# ASSESSMENT REPORT

## Section 75W Modification Eastern Creek Waste Facility (06\_0239 MOD 1)

SITE LAYOUT PLAN
 CHUTE LAYOUT
 MARCH 2010
 1:3000 scale
 090507/DI-EP-MP A 101 - 3/F

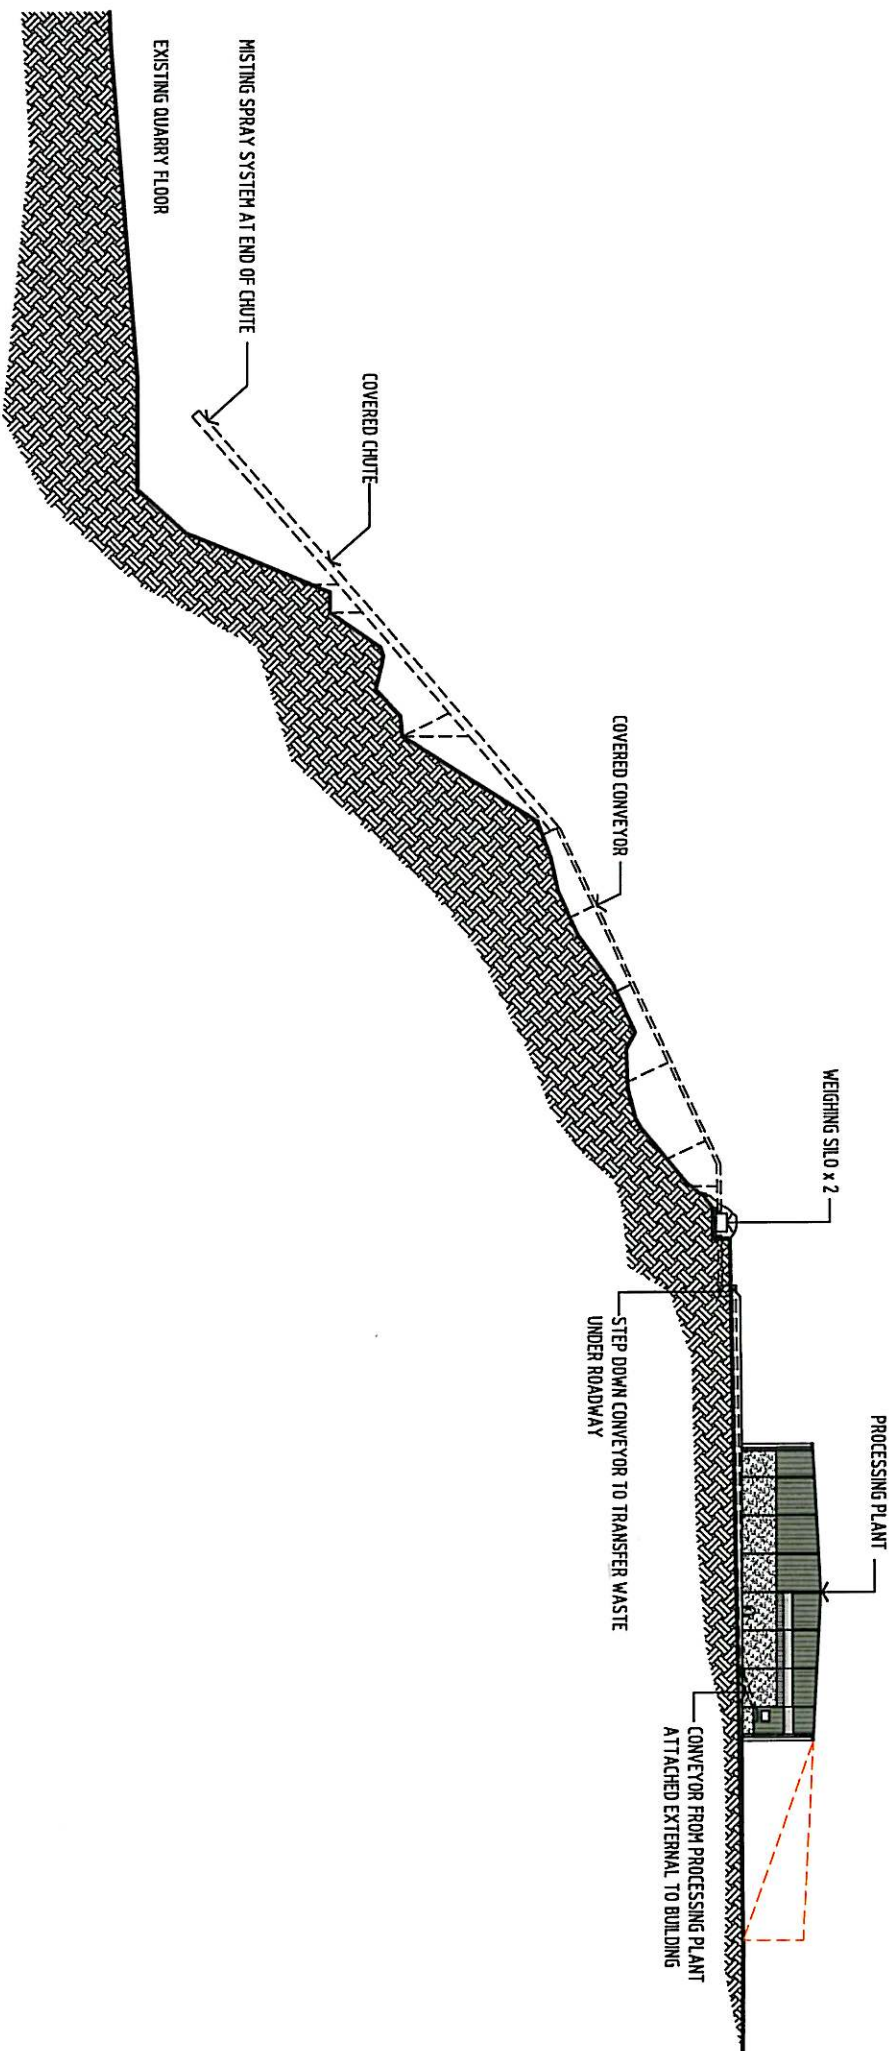
With regard to the modification, emissions due to the use of the haulage road would be significantly reduced as this would only be utilised for transferring asbestos waste to the base of the quarry pit or during maintenance operations in the event that the conveyor/chute system breaks down.

The conveyor and chute would be covered and are therefore not expected to be a source of dust emissions. The conveyor loading point would be located within the MPC building and is not considered to be a source of dust. The chute (and canvas sock) release point at the base of the quarry would be fitted with fine mist sprays to minimise dust.

- ensure that the conveyor/chute system is fully enclosed;
- ensure that the waste drop height of no more than 3 metres between the end of the sock and the base of the quarry;
- incorporate fine mist sprays at the discharge end of the chute to minimise dust;
- prepare a conveyor/chute system maintenance and management plan that includes a maintenance schedule;
- detail contingency measures in the event that the system breaks down, or is not coping with the intended quantities of waste; and
- ensure that each greenwaste bay has an individual cover and anaerobic equipment fitted to reduce odour and the generation of leachate.

SITE LAYOUT PLAN
 GREEN WASTE
 CONTAINMENT WALLS
 090507/ DI-EP-MP A 101 - 5 / F
 MARCH 2010
 1:3000 scale

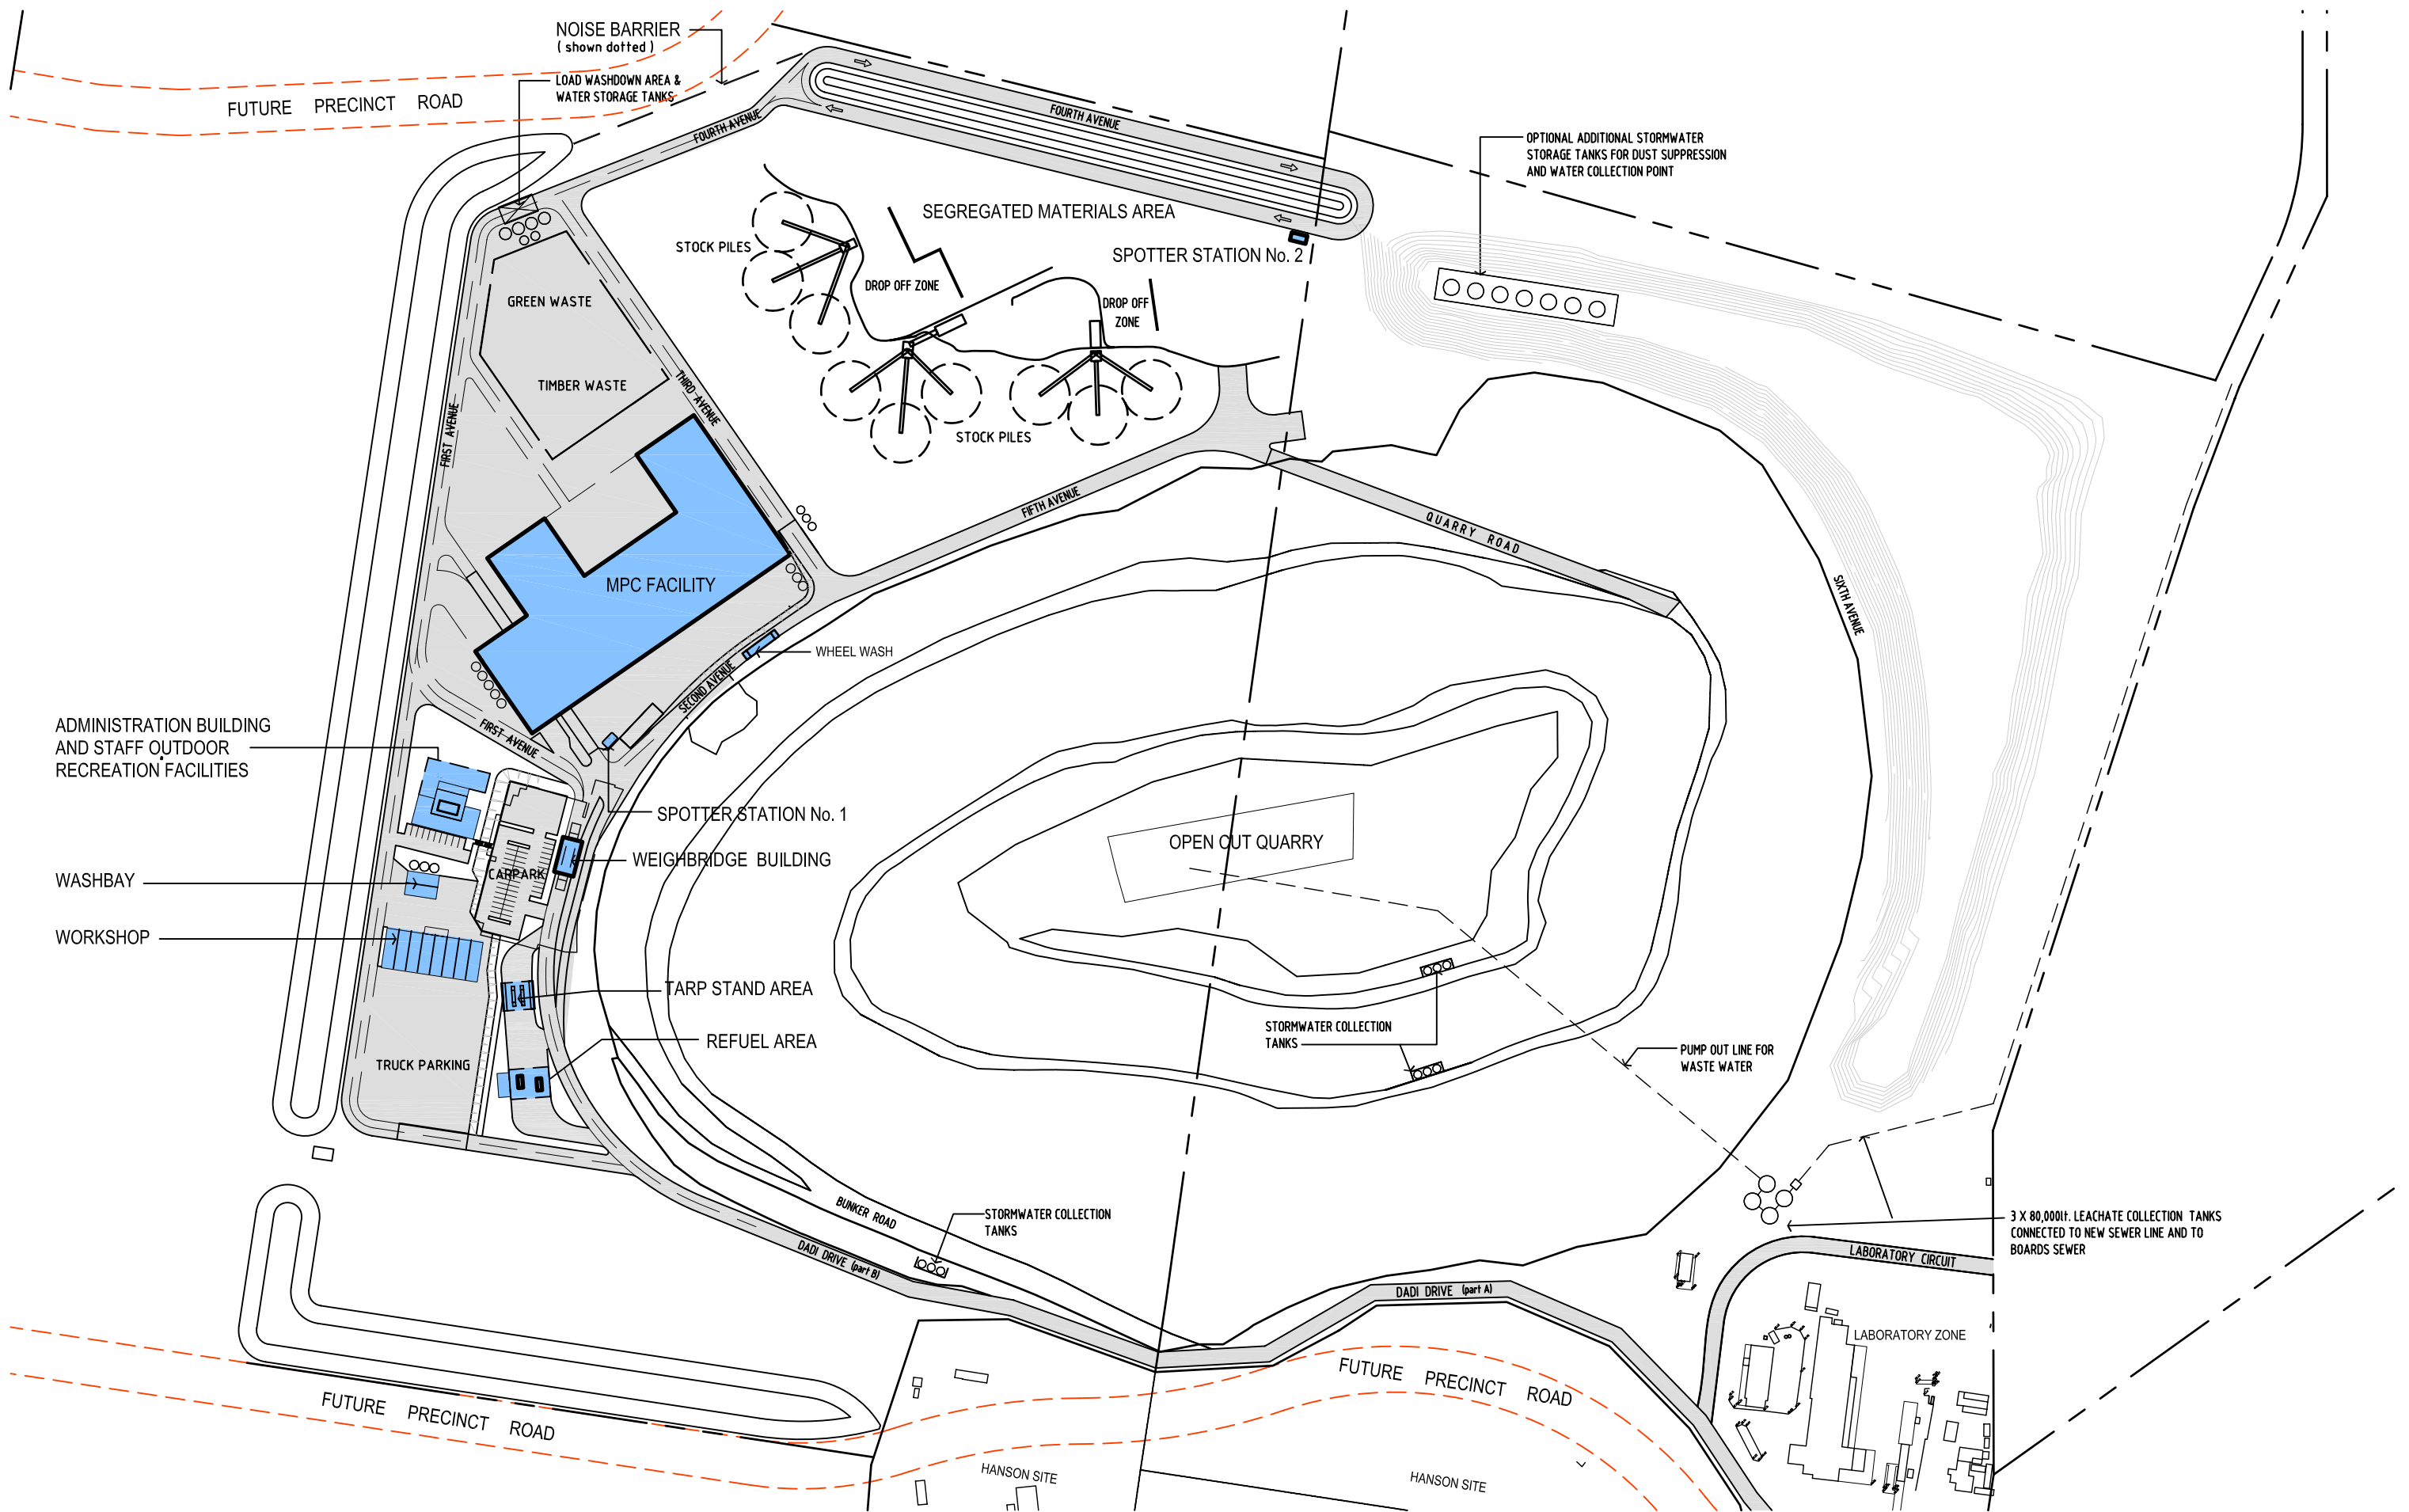
As part of this modification, ThaQuarry proposes to construct concrete bay walls within the area designated for receipt and processing of greenwaste. This is likely to have the effect of reducing odour emissions from the site at nearby residences due to the fact that construction of concrete bay walls would allow the greenwaste composting area to be more easily fitted with equipment to aerate the composting greenwaste and also to install covers over the greenwaste.

The Department and DECCW consider that while the installation of concrete bay walls themselves would do little to alter the emissions from the site, the management controls associated with their installation (ie. namely aeration and covering of the greenwaste) could potentially reduce odour levels from the site. Further, the Department considers that potential air quality impacts associated with the conveyor/chute would be minimal and could largely be managed through existing conditions of approval.

SITE LAYOUT PLAN
 2 WAY ROAD
 SEGREGATED MATERIALS AREA
 090507/ DI-EP-MP A 101 - 7 / F
 MARCH 2010
 1:3000 scale

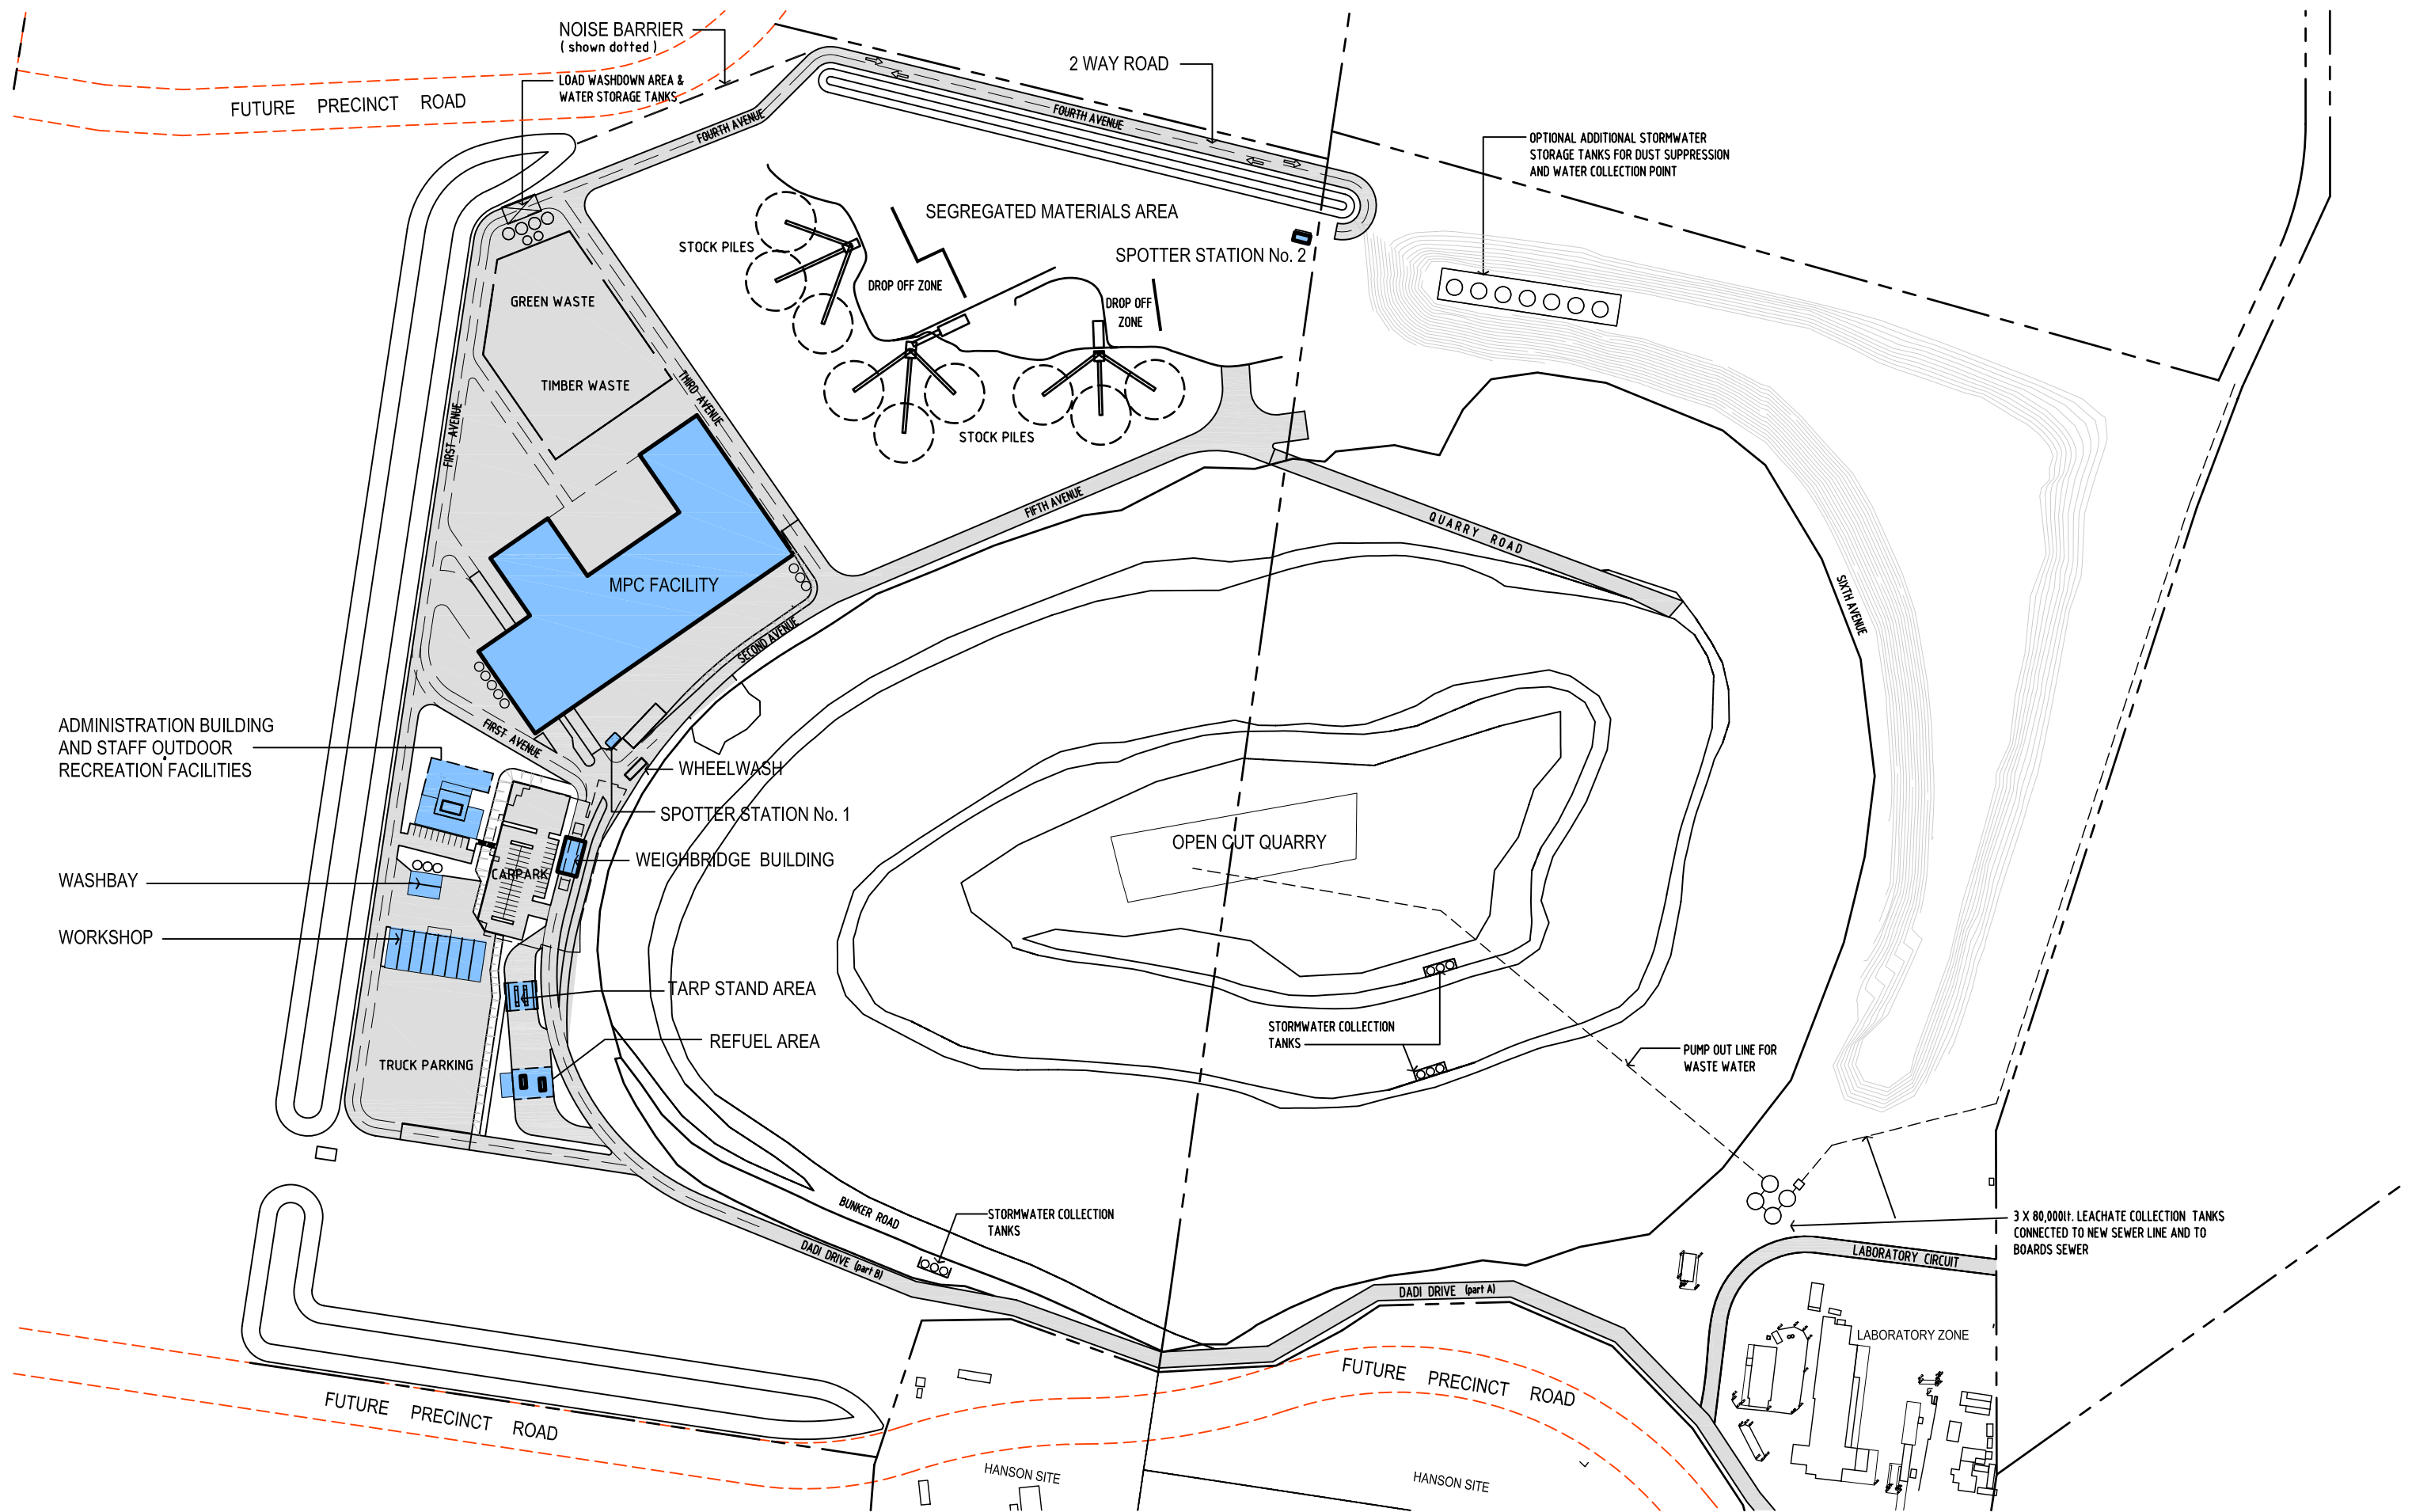
<i>Two Way Traffic on Fourth Avenue</i>	<ul style="list-style-type: none"> <li>▪ Fourth Avenue, located to the north of the site, is a roadway 8 metres wide approved to cater for one-way vehicle traffic movements.</li> <li>▪ ThaQuarry seeks to modify the project approval to enable this roadway to cater for two-way vehicle movements as depicted in Figure 3.</li> <li>▪ There would be no change to the number of vehicles entering and leaving this area of the site so dust, fuel usage, greenhouse gas and noise impacts would not change.</li> </ul>	<p>No additional conditions required.</p>
